Response to Submissions

The New Primary School at Warnervale

PREPARED FOR
SCHOOLS INFRASTRUCTURE NSW
JANUARY 2020

CLIENT  
DEPARTMENT OF EDUCATION  
DRAWING TITLE:  
GENERAL ARRANGEMENT -  
MAIN SCHOOL ENTRY

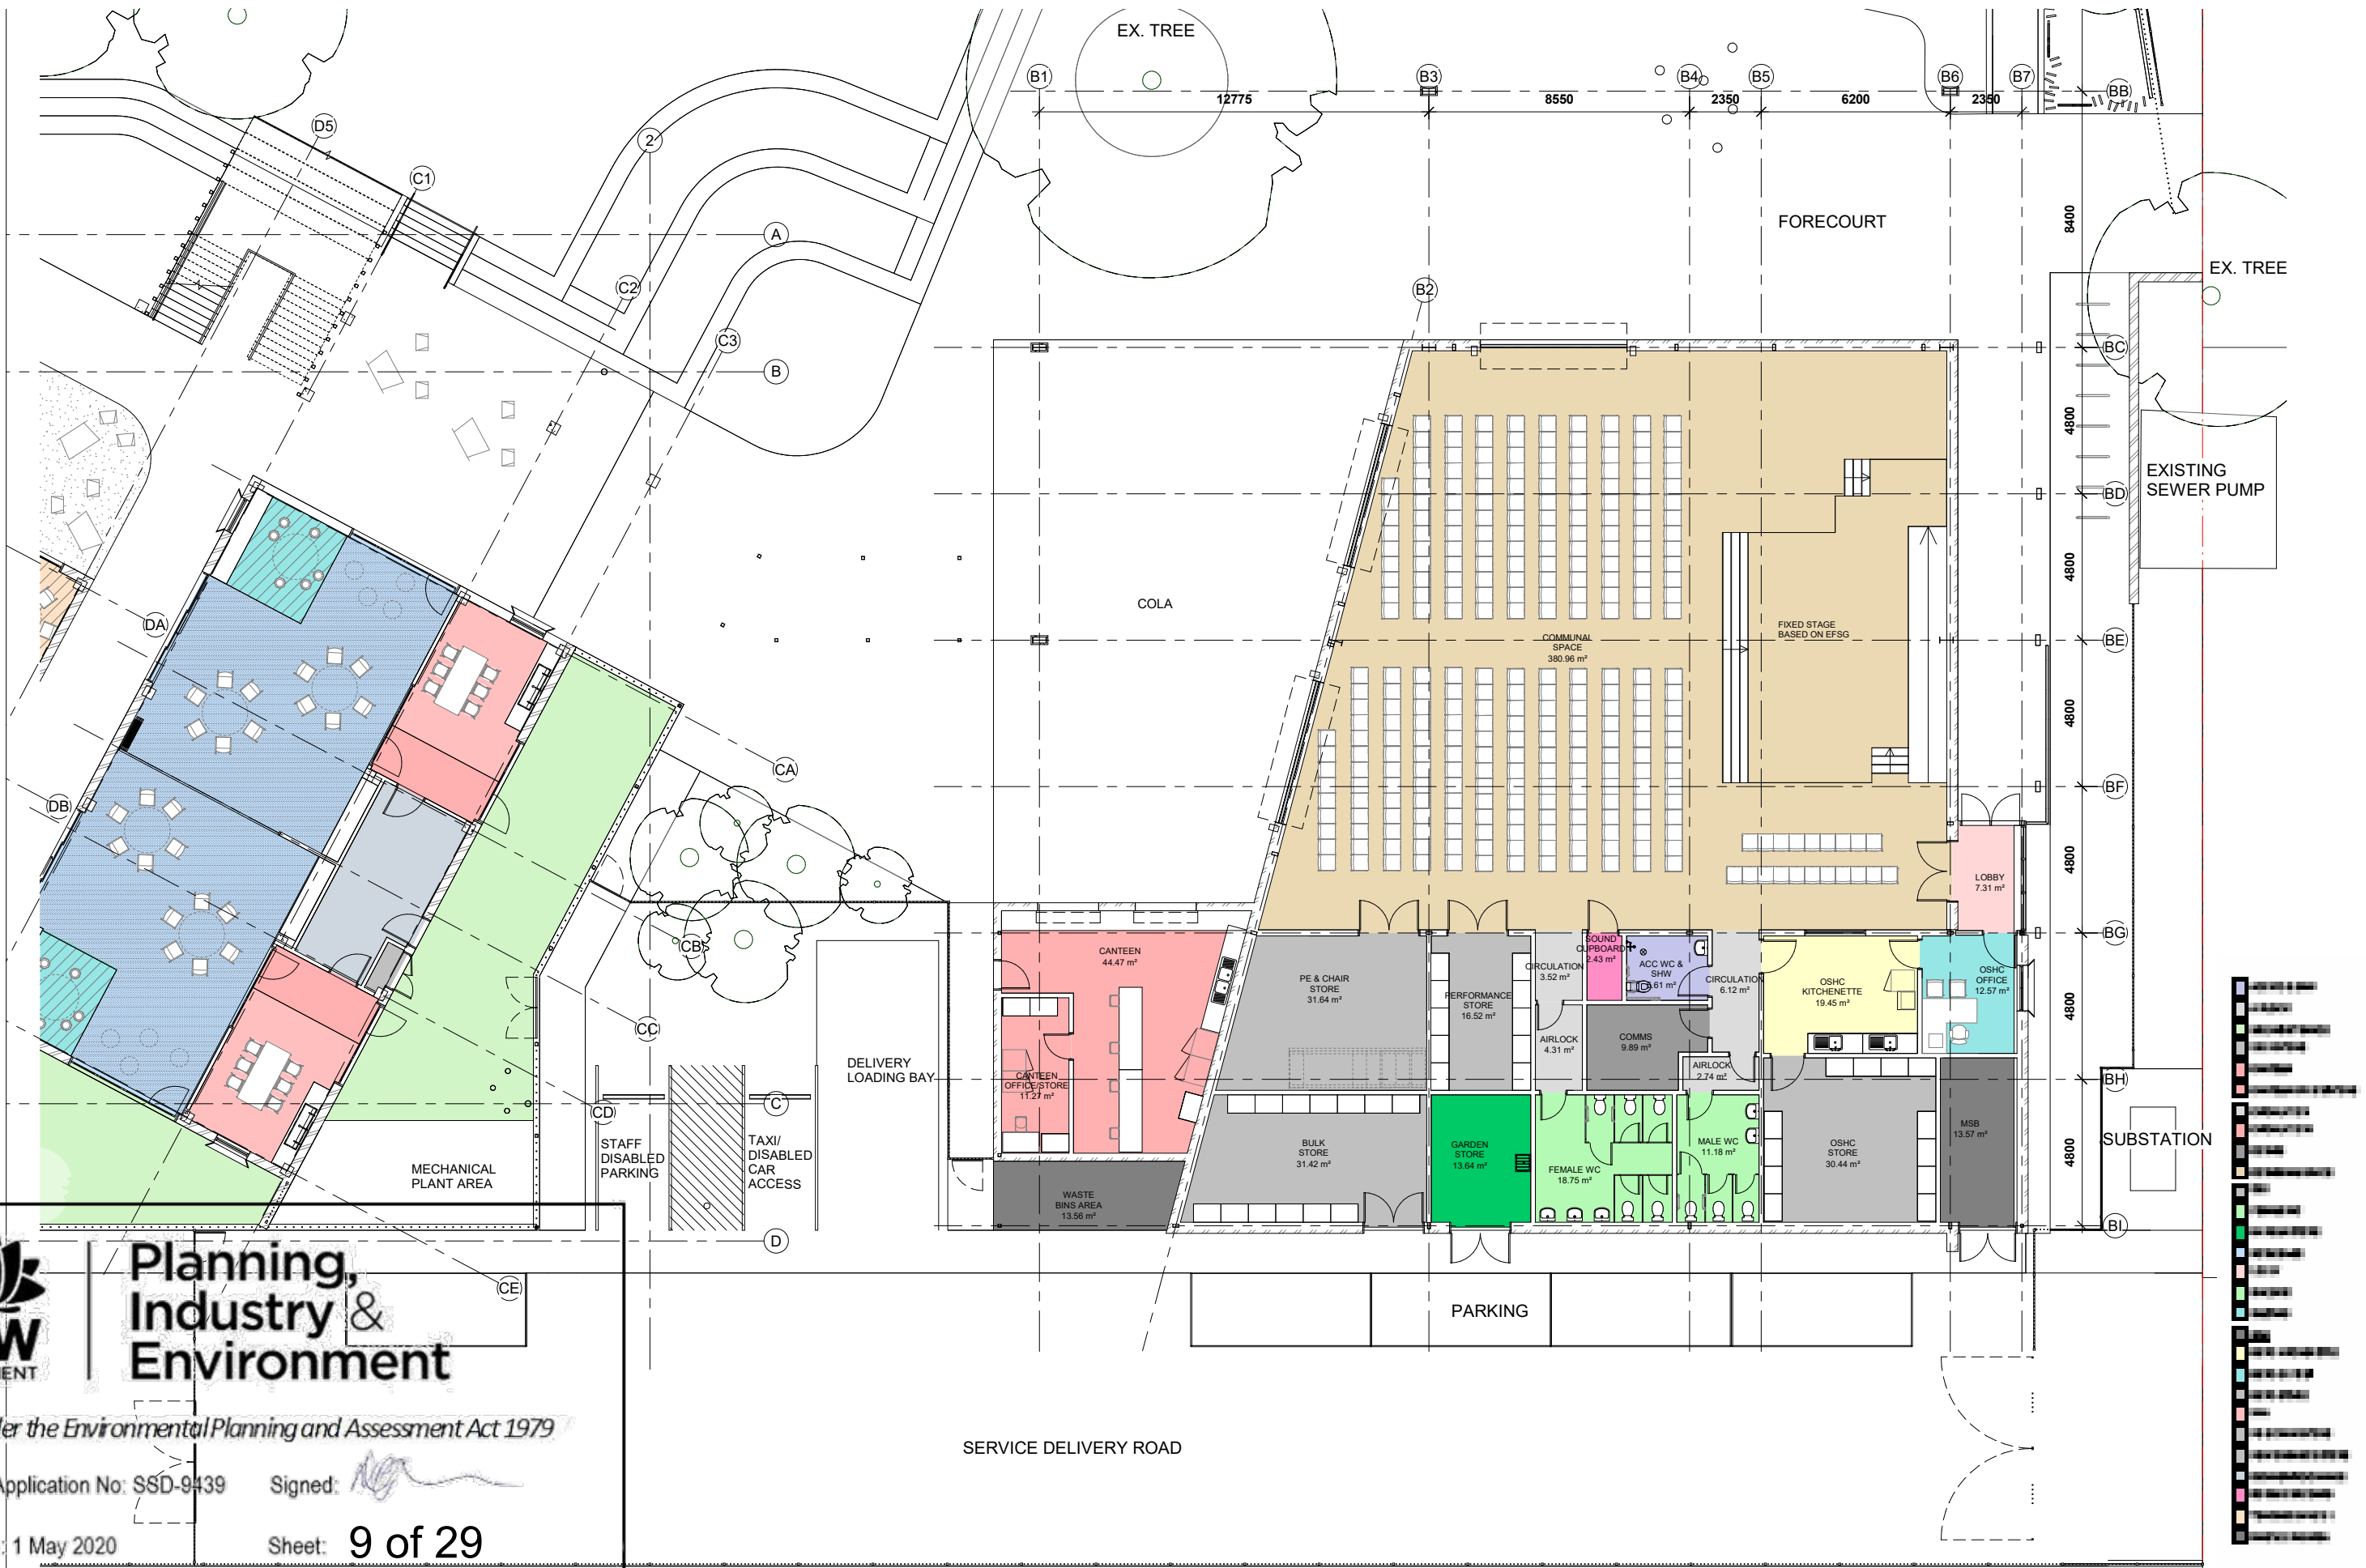
It is recommended that the western carpark be redesigned so the set-down and pick-up is directly adjacent to the school as this will be a safety issue as students will be crossing the staff carpark. Eliminate the staff spaces and re-locate the median closer to the school to facilitate 90 degree angle parking both sides in the western carpark. Delete the turning head and increase the number of spaces.	Staff parking is currently already proposed to be separated from the drop-off area by a fence, with a pedestrian crossing provided for students to travel between the drop-off area and the school. Refer to comments above in relation to the requirement for 90 degree parking.	Appendix K
	The proposed boundary re-alignment will result in the western carpark becoming a Council asset. This is not supported.	<p>Given the location of squirrel glider habitat on nearby residential development sites, it is understood that the road network envisioned within the WDCP 2013 is likely to be varied in the near future. For example, half-road construction along the eastern boundary of the western adjoining property may not be possible as a consequence of the future road arrangement. However, given the Asset Protection Zone (APZ) required along the eastern boundary of the subject site, a future full-width road (rather than the required half-width road) can be delivered within this part of the subject site, utilising access to the proposed drop-off / pick-up zone.</p> <p>The drop-off / pick-up zone will be constructed to Council standards, and dedication of the car park, will provide Council with an option for an</p>	N/A
